20 October 2020

**Subject: SSD-10478 - Change of Use – Alesco Senior College**  
**Lots 18, 19 & 20 DP 23975**  
**27 Chapman Street, Charlestown NSW 2290**

Figure 11 | Proposed courtyard landscaping (Source: Applicant's RtS)

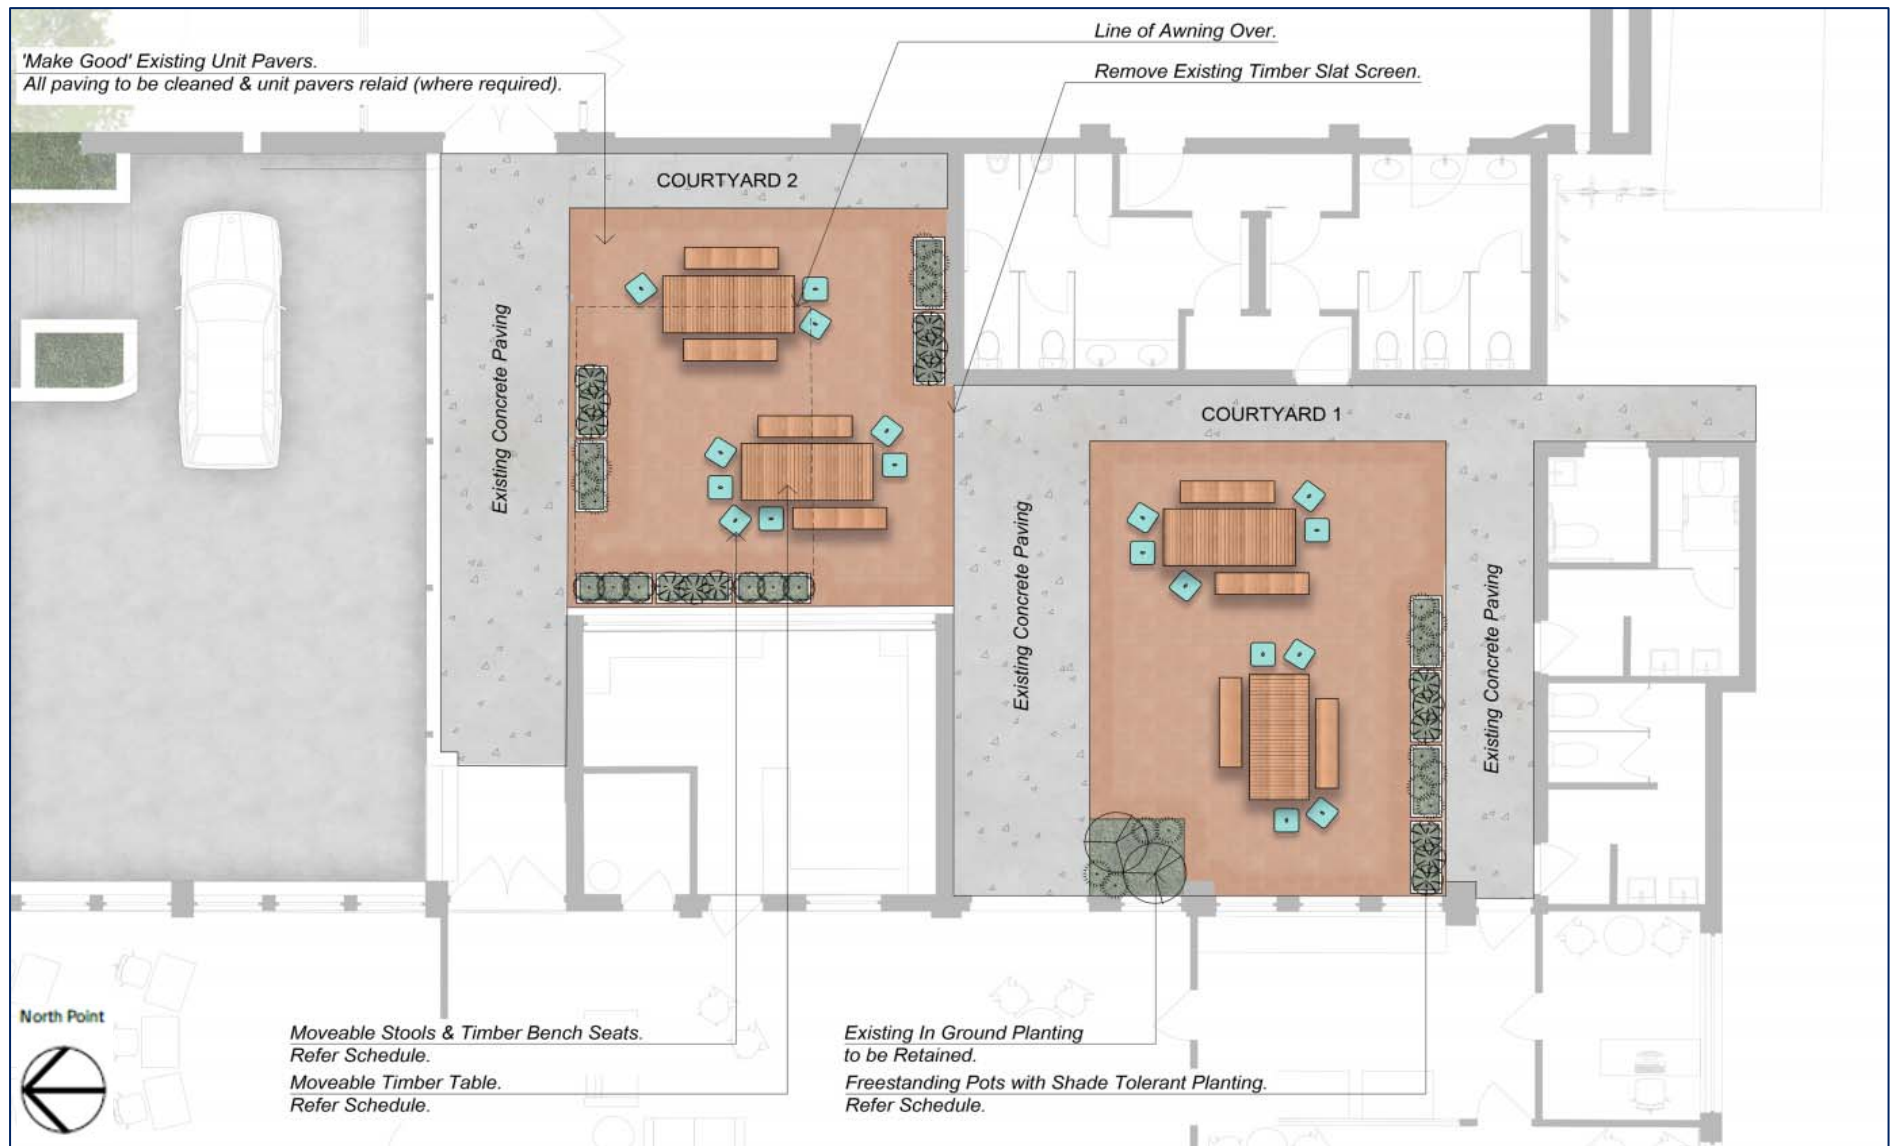
**Landscaping** – The Landscape Plan should include more plantings along the periphery of the site and within the front setback to improve the street appeal and minimise the visual impact of the carpark at the frontage.

Additional plantings at the frontages can improve the amenity and create a strong entry statement to the building. Council's Landscape Architect has recommended the following conditions for landscaping:

- A minimum of one 75 litre shall be planted on the south western corner of the site and eastern side of the pedestrian ramp to define the entry and provide a high amenity corner element that would create a welcoming effect to the corner location. The species of tree shall be determined by the landscape consultant.
- A minimum of two 75 litre trees are to be planted within the front setback to Chapman Street to provide shade and amenity and thereby improve the quality of the outdoor space. The species of tree is to be determined by the landscape consultant and be representative of the Lake Macquarie City landscape character.
- The existing street tree on Chapman Street shall be retained and protected from all construction works and impacts.

- One 75 litre street tree that is centred between the existing inlet pit and driveway on St Albans Close shall be provided. The street tree shall be species Eucalyptus sideroxylon 'Rosea'. The street tree shall be planted as per LSD-PLA-02 of Lake Macquarie City Council Standard Landscape Drawings (Tree pit with stakes in turf verge) which is available at the following weblink:

- The existing trees on the south-eastern corner shall be retained and protected from all construction works and impacts.
